Engineers Comments Regarding Surface Water Drainage

Application Reference:	A/177/25/DOC	Reviewer Reference:	ADC/EXT3/RW
Planning Officer:	Kathryn Welch	Date of Review:	26/02/2026
Site Name:	Rustington Golf Centre Golfers Lane Angmering BN16 4NB		
Application Description:	Approval of details reserved by condition imposed under A/163/24/PL relating to conditions 6-surface water drainage scheme and 7-maintenance and management of surface water drainage system.		
Assessment Number:	2 of 2

TYPICAL SWALE DETAIL

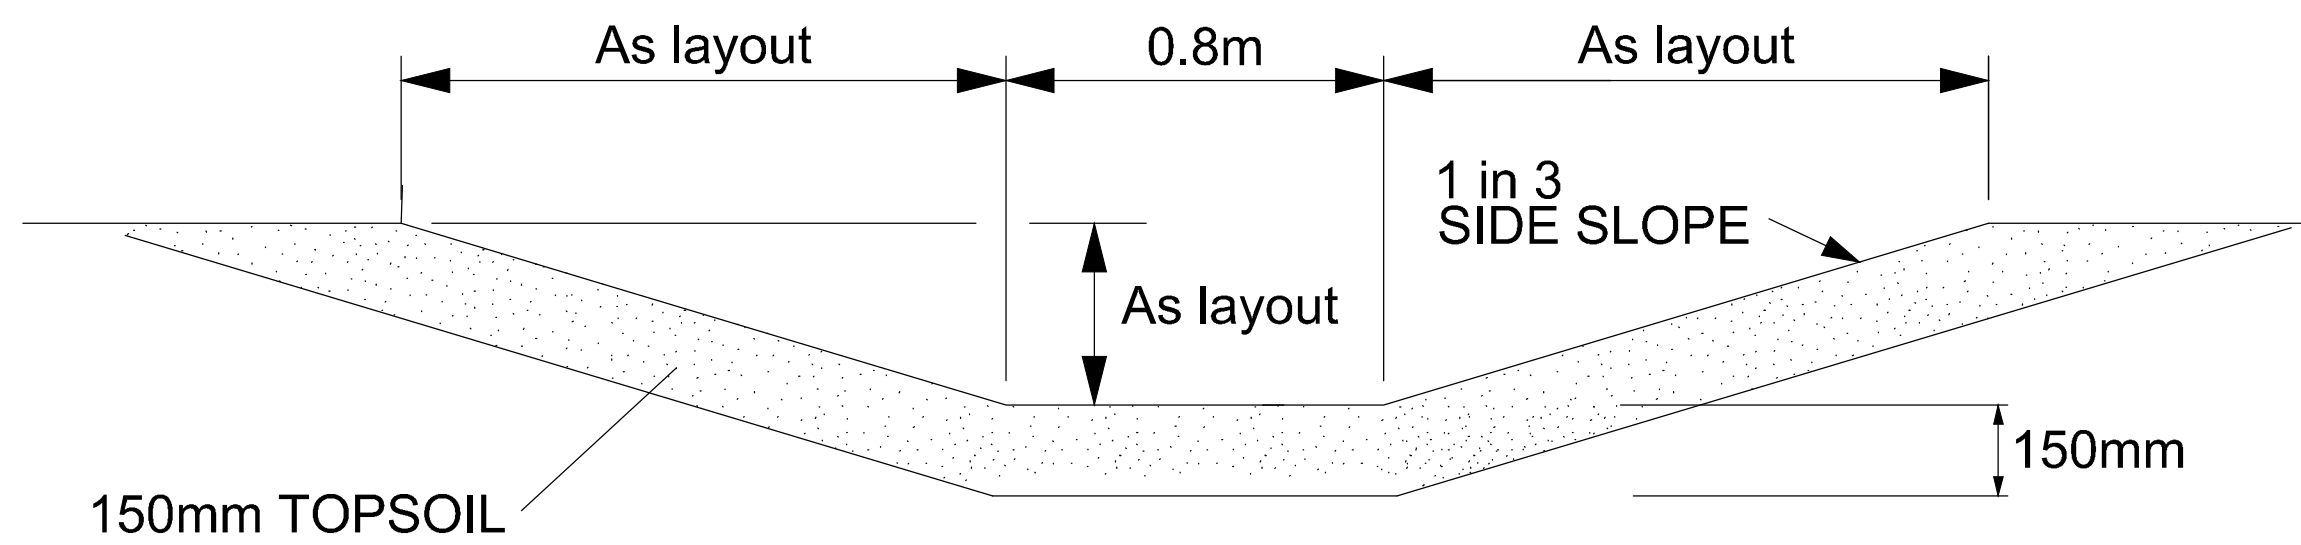
14.	Please include the area of the swale in your contributing areas plan/calculation.	Now included.	Noted on calculations pack		
15.	It appears that the swale is immediately adjacent to a group of trees. Please clearly demonstrate on plan the root protection areas of these trees and measures to protect drainage features from root damage. (If the swale needs to be lined to prevent groundwater ingress – if there is less than 1m of unsaturated ground between the base of the swale and the peak groundwater level.)	RPA for adjacent group of trees now clarified on the drawing – and swale design adjusted to suit. The tree group is entirely located on the west side of the existing fence (remaining in situ). It is not expected that the tree root will impact the proposed swale in its updated location.	noted
